Your Ref: OWPC18032
Our Ref: FG/43/18/DOC 08-03-2018
Please ask for:
Mrs A Gardner

Approval of details reserved by condition imposed under FG/69/16/OUT
(APP/C3810/W/17/3166634) relating to condition 6-proposed traffic light system.

Paddock House 44 Ferringham Lane Ferromg

Thank you for your internet representation made on 26th April 2018 which has been recorded
as '**an objection**' with the comments as follows:

ACCESS CONFIGURATION & CONSTRUCTION SPECIFICATION

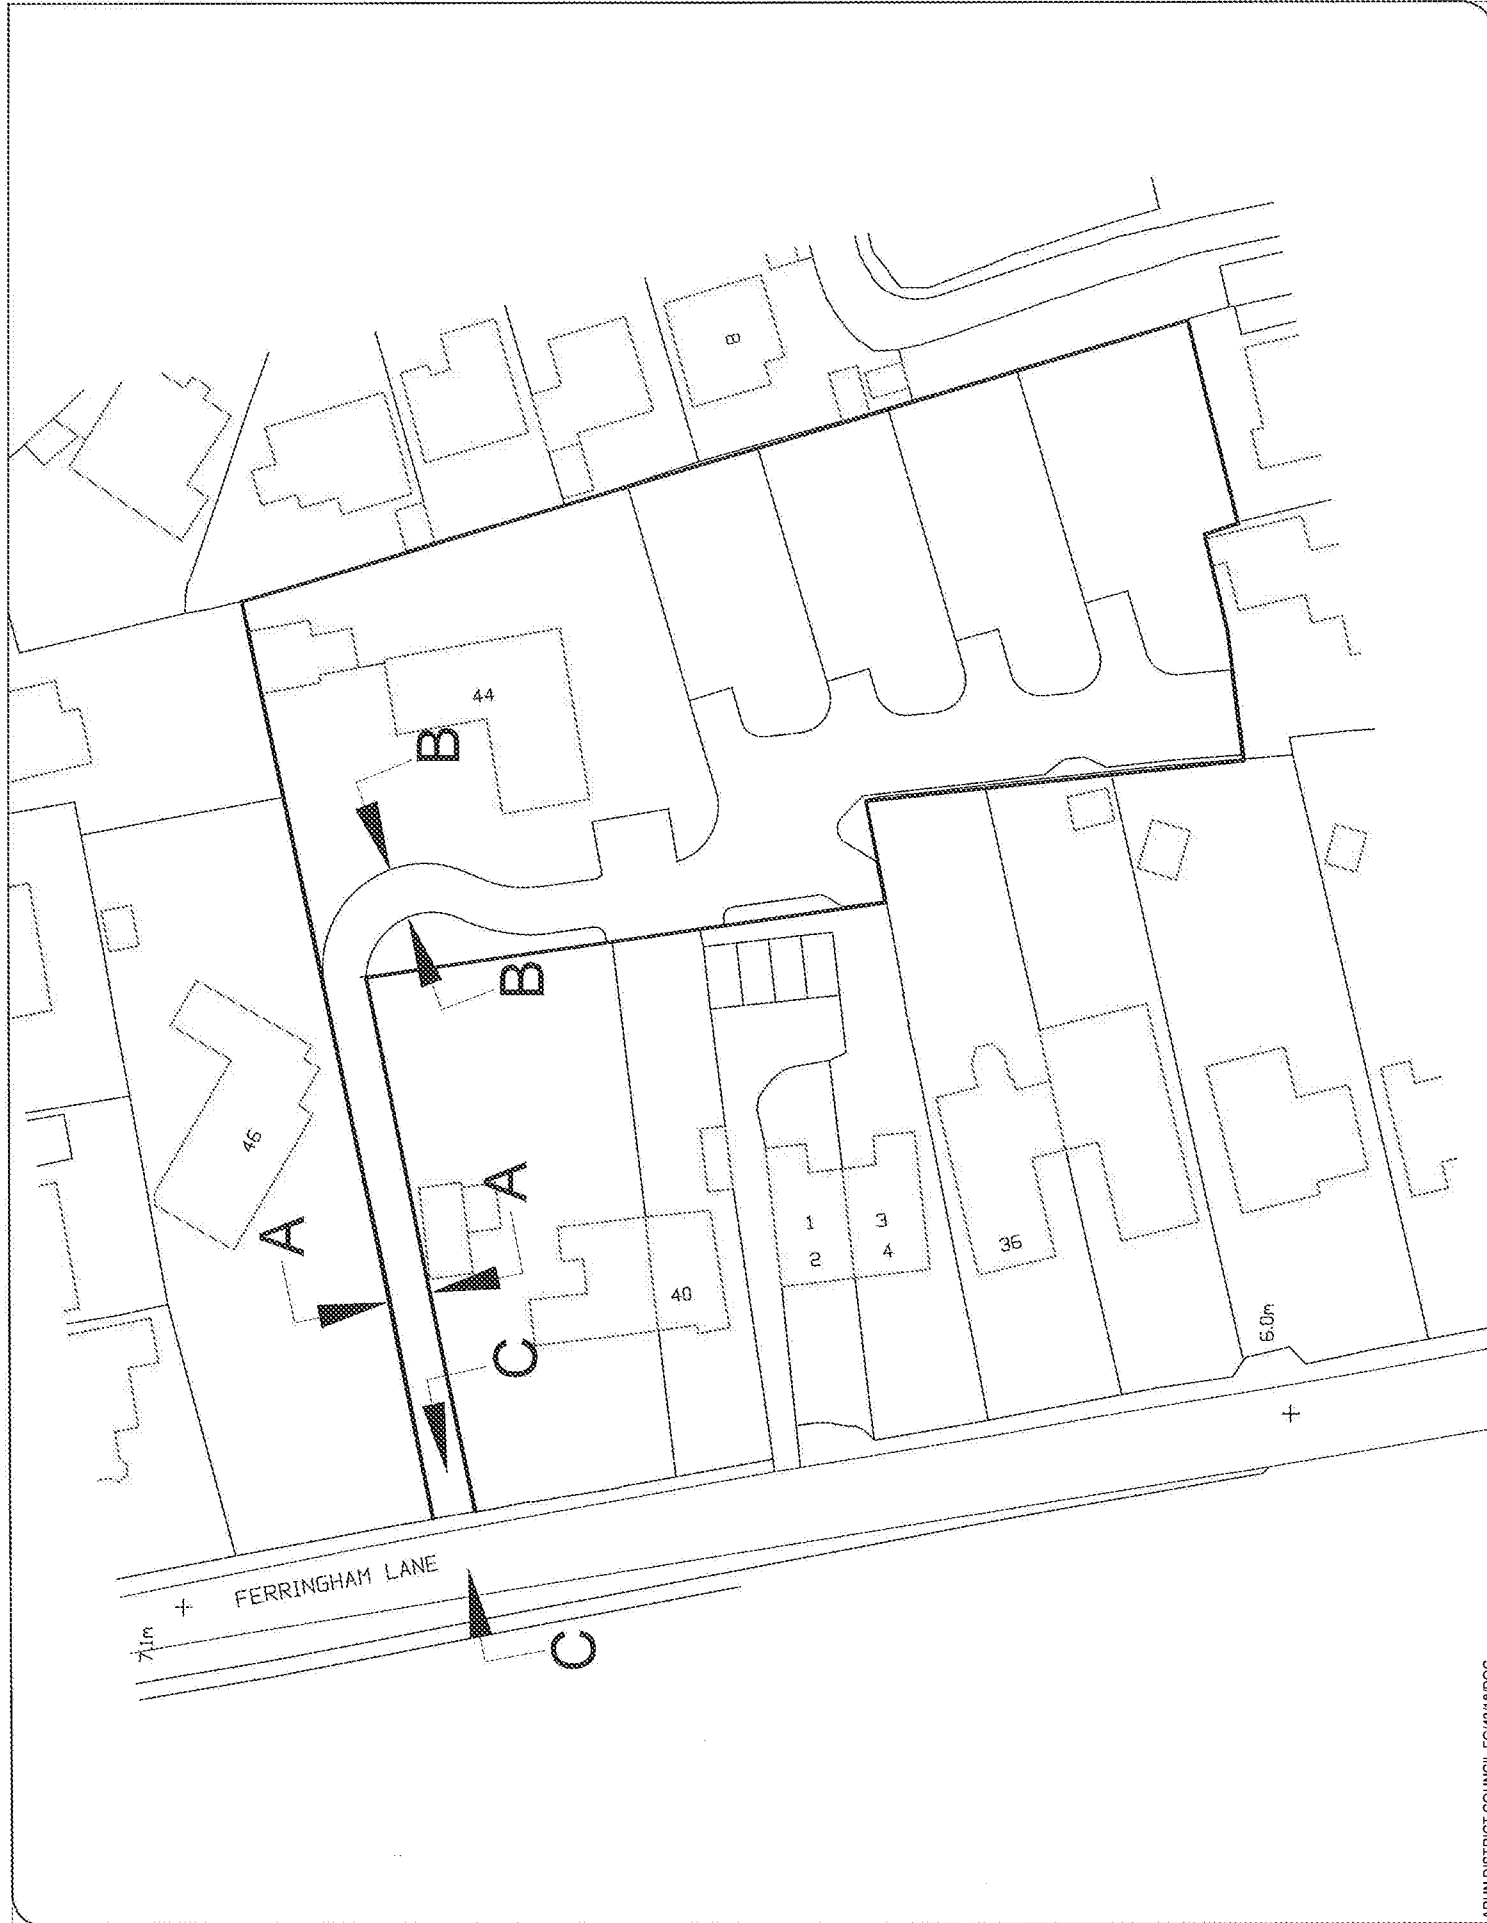
*Also how can any work begin to the proposed development when access has to be 4
meters wide as stipulated.*

*At current access is 360 cm or 12 foot as sold back in 1954 by the surrounding land owner
to*

Make a small narrow access lane to 44 Ferringham Lane.
